CITY OF ALBUQUERQUE

**Re: Zia Auto Remodel
4913 Menaul Blvd.
Traffic Circulation Layout
Architect's Stamp 01-24-18 (H17-D114)**

Based upon the information provided in your submittal received 01-24-18, the above referenced plan cannot be approved for Building Permit until the following comments are addressed:

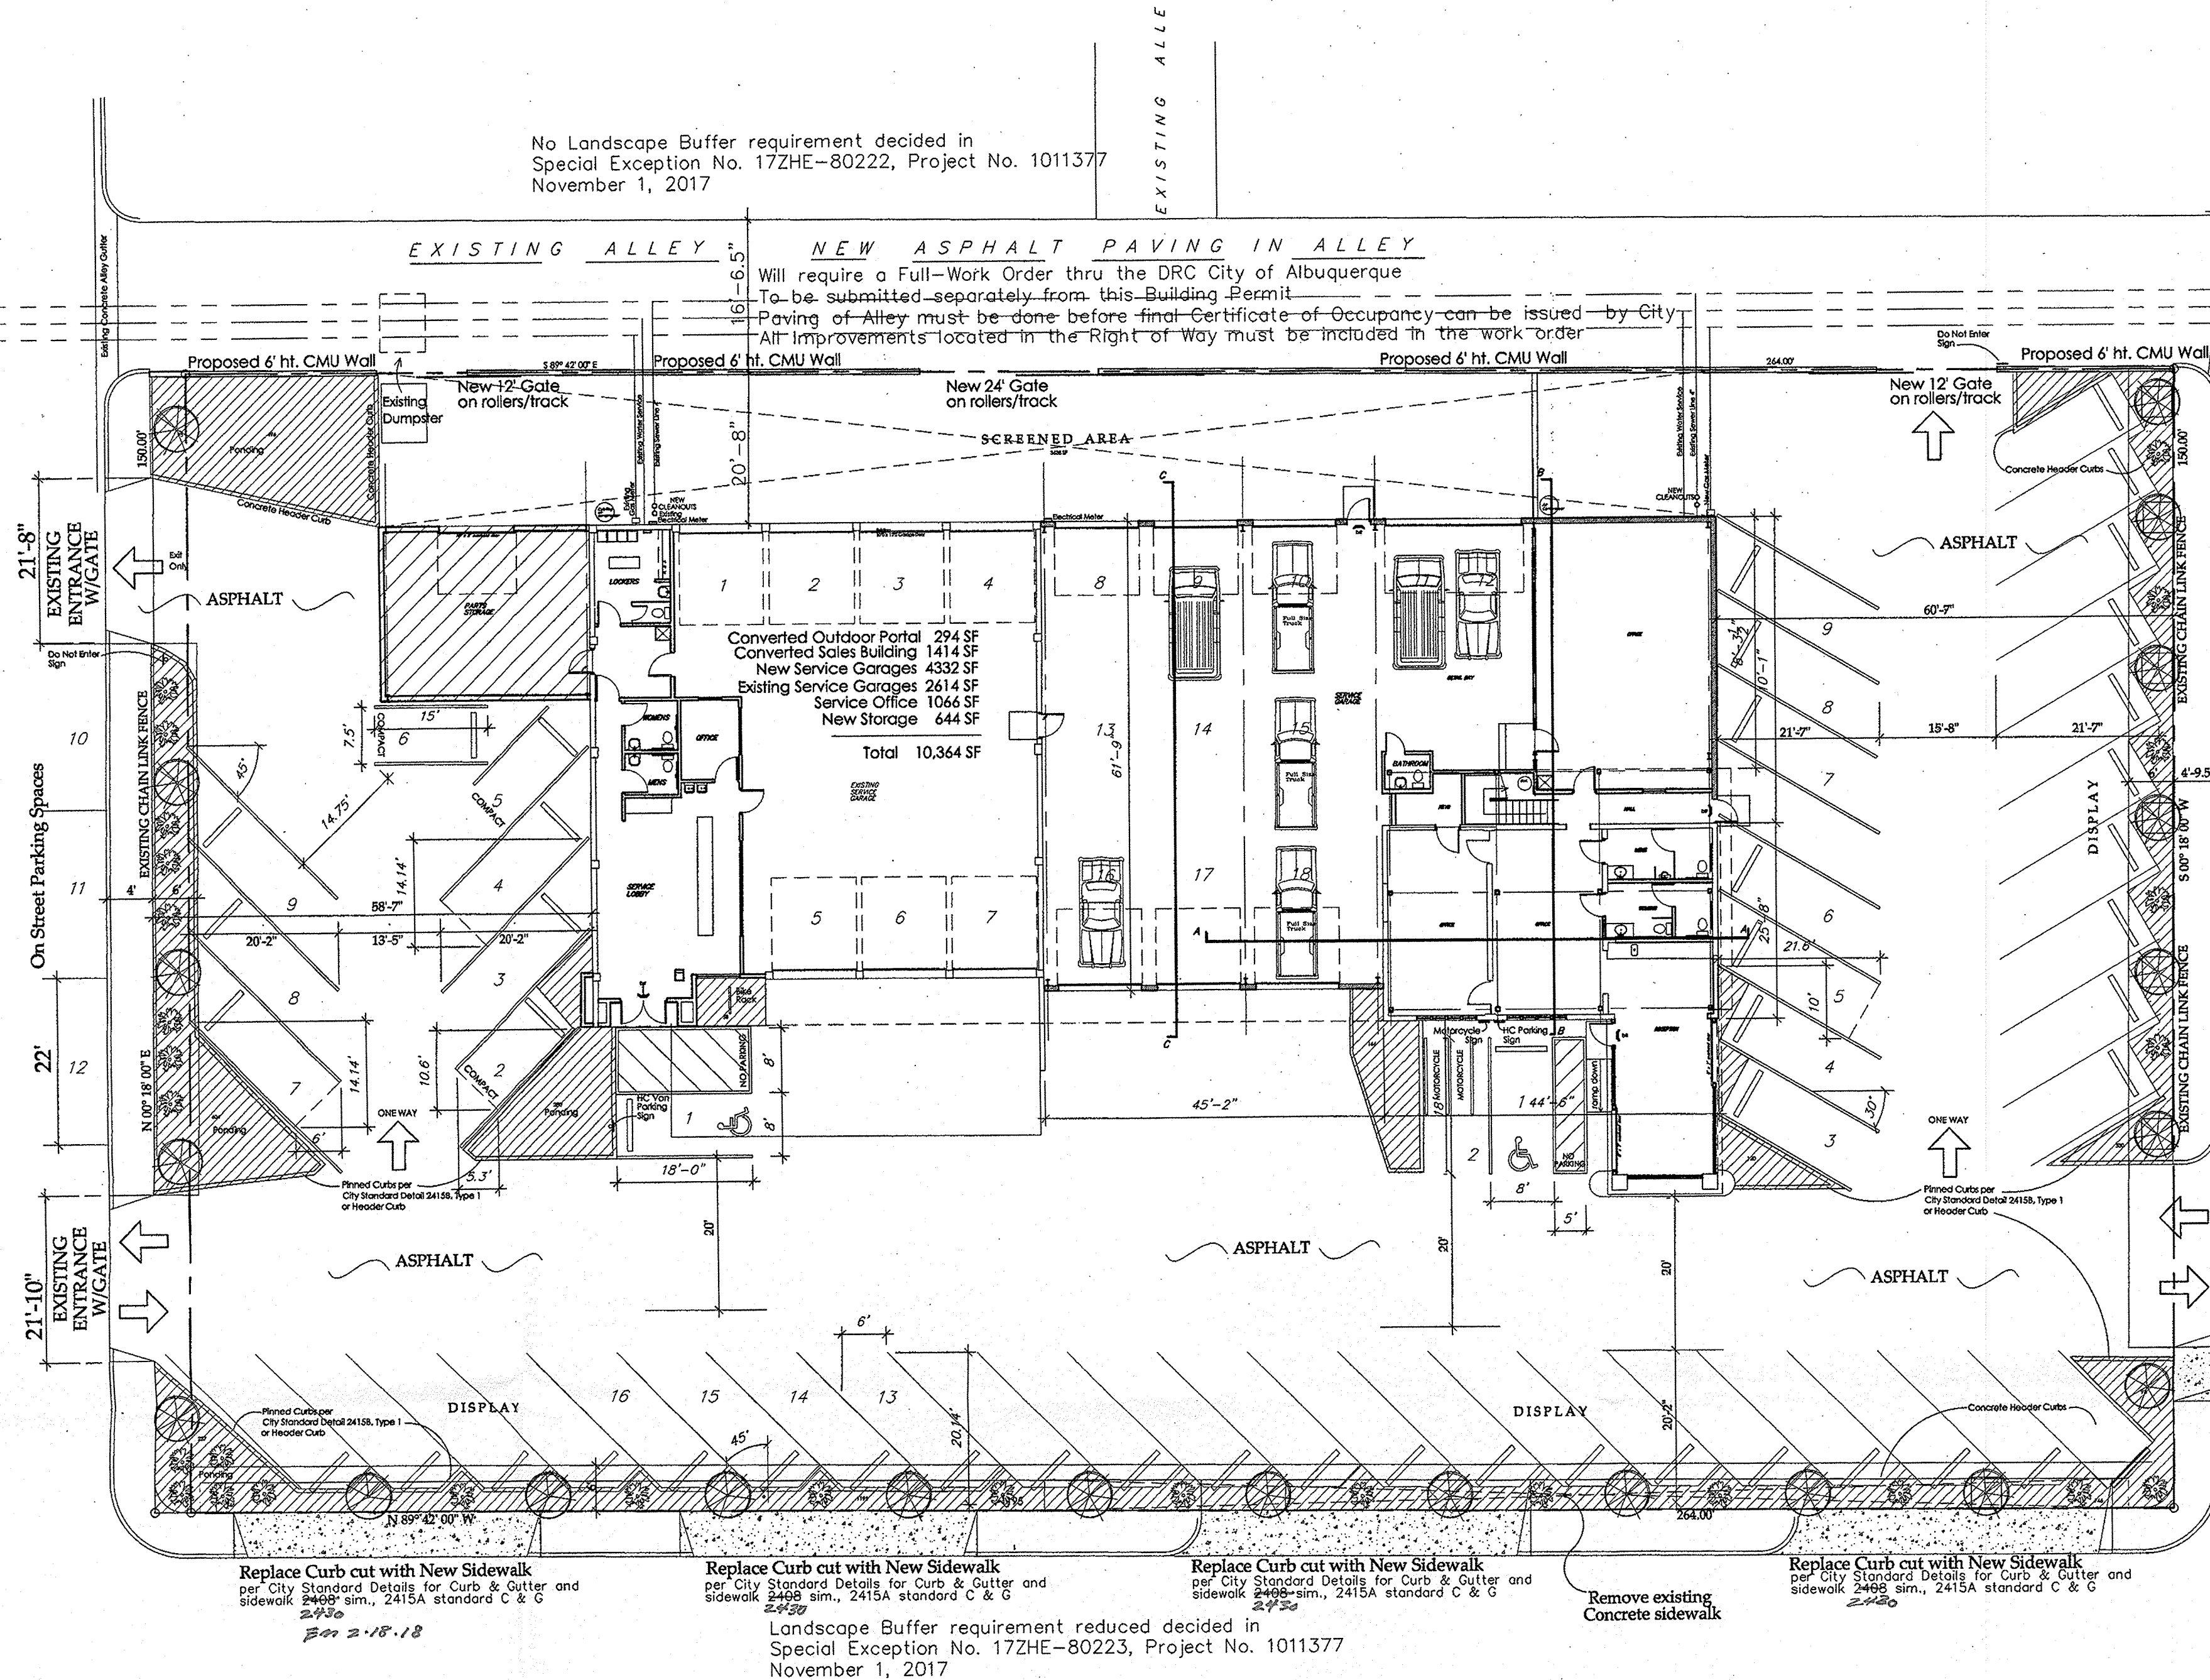
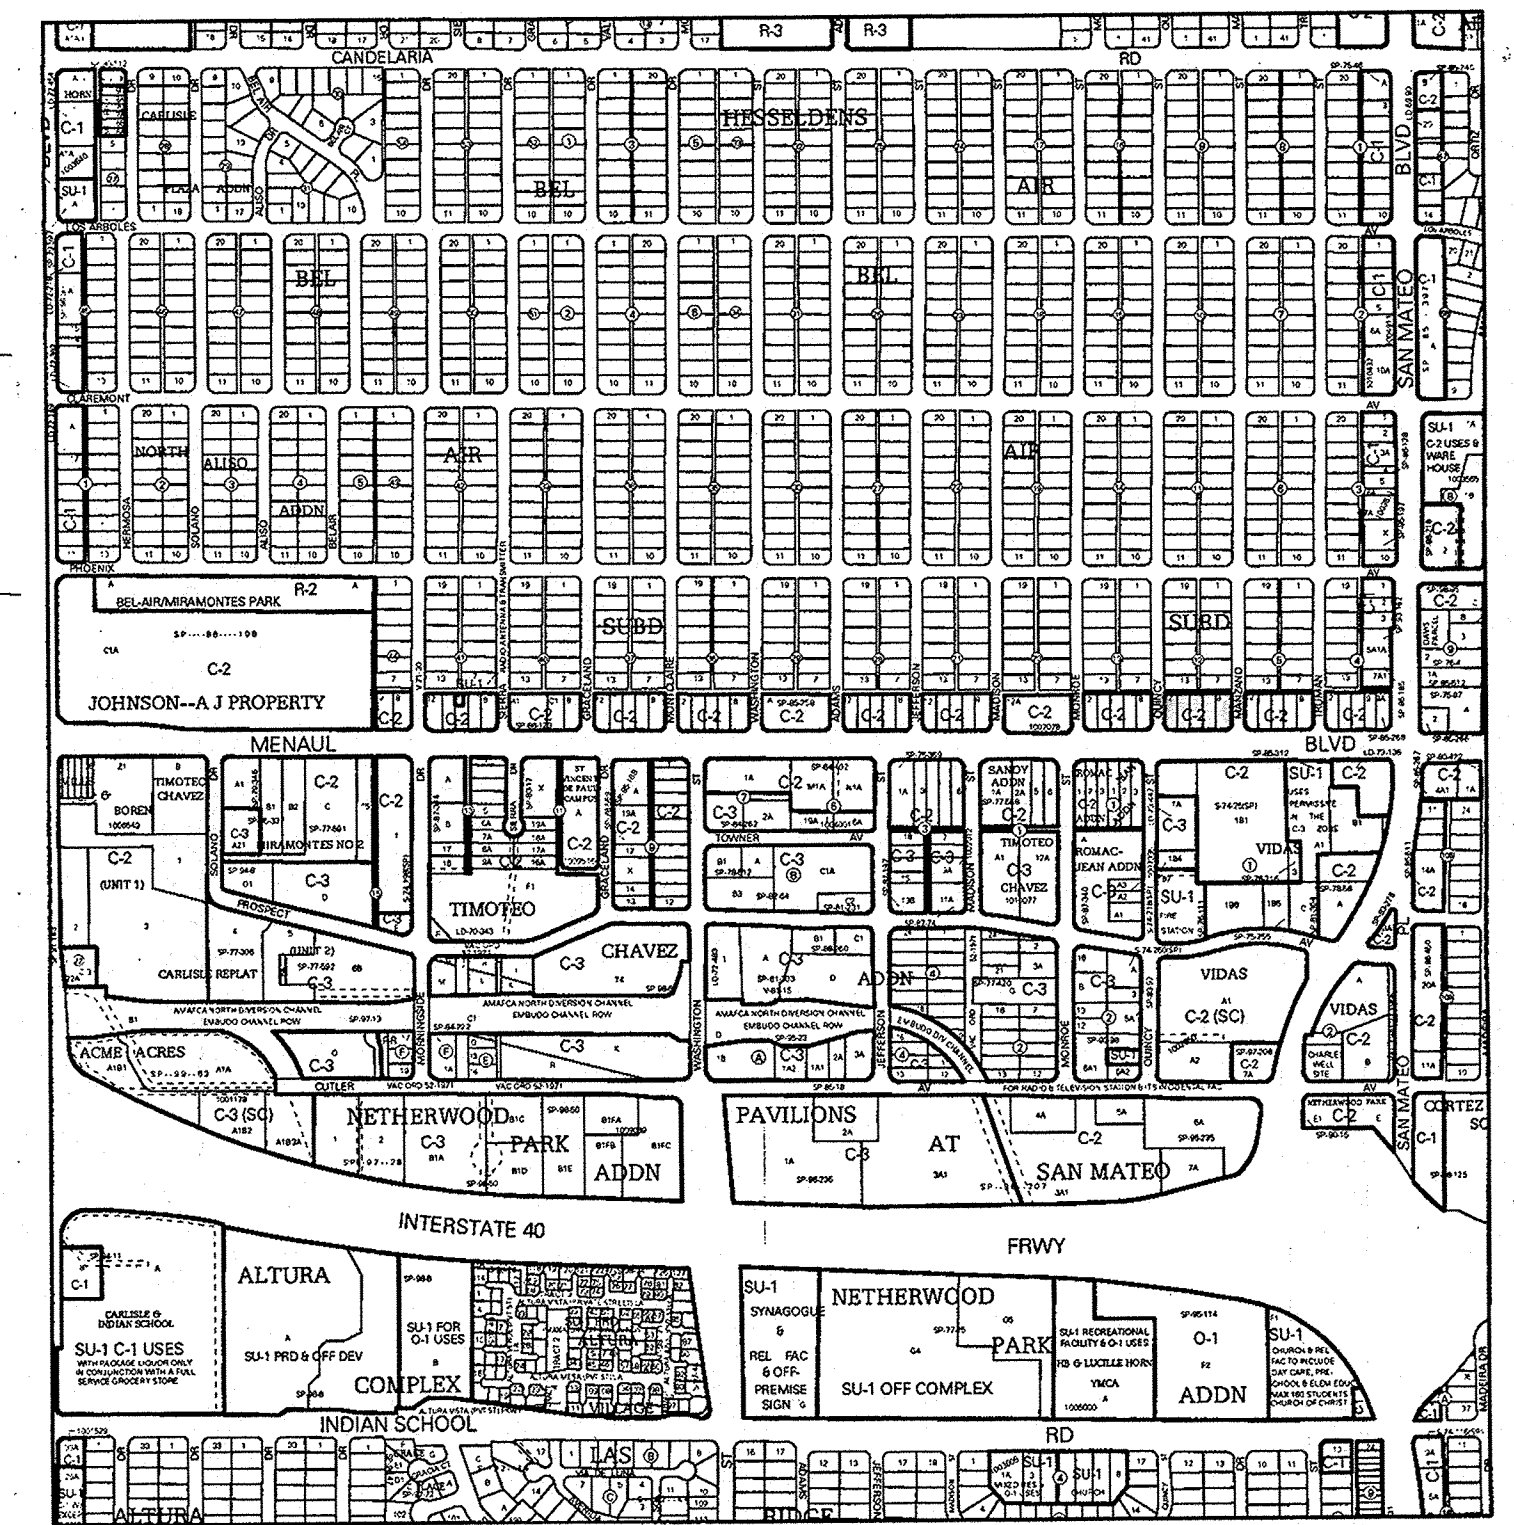
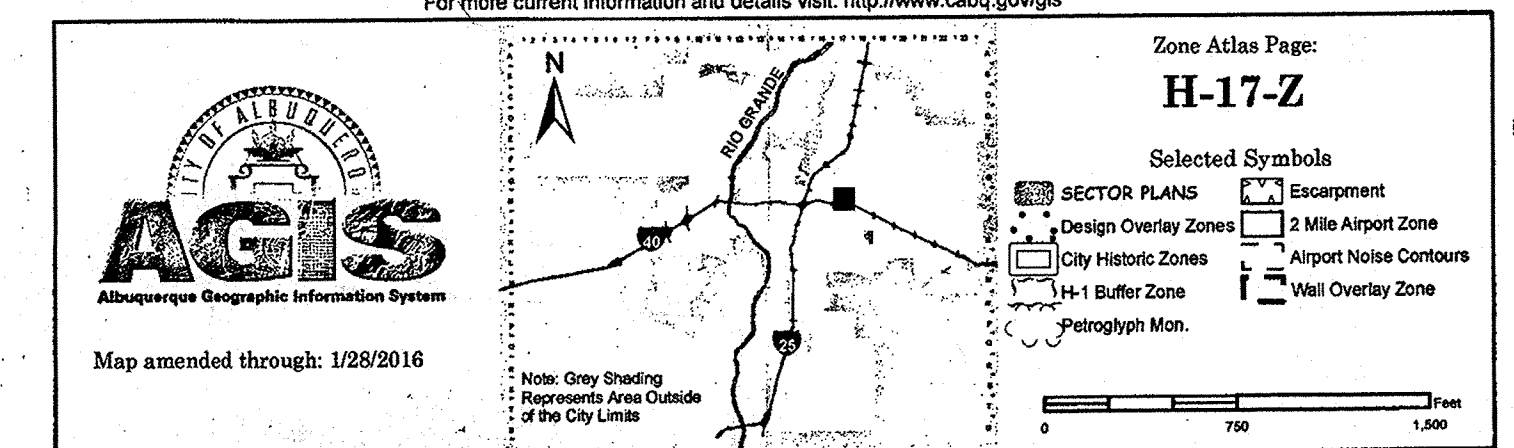
1. A scale of 1"=20' is recommended for sites less than 5 acres.
2. Dumpster apron cannot extend into the alley.
3. Label the compact parking spaces by placing the words "**COMPACT**" on the pavement of each space.
4. One-way vehicular paths require pavement directional signage and a posted "**Do Not Enter**" sign at the point of egress. Please show detail and location of posted signs.
5. Please provide the widths of the existing drive entrances.
6. Lot line should not cross through buildings; DRB may be needed for re-plotting. Please check with zoning if the lot lines need to be removed.
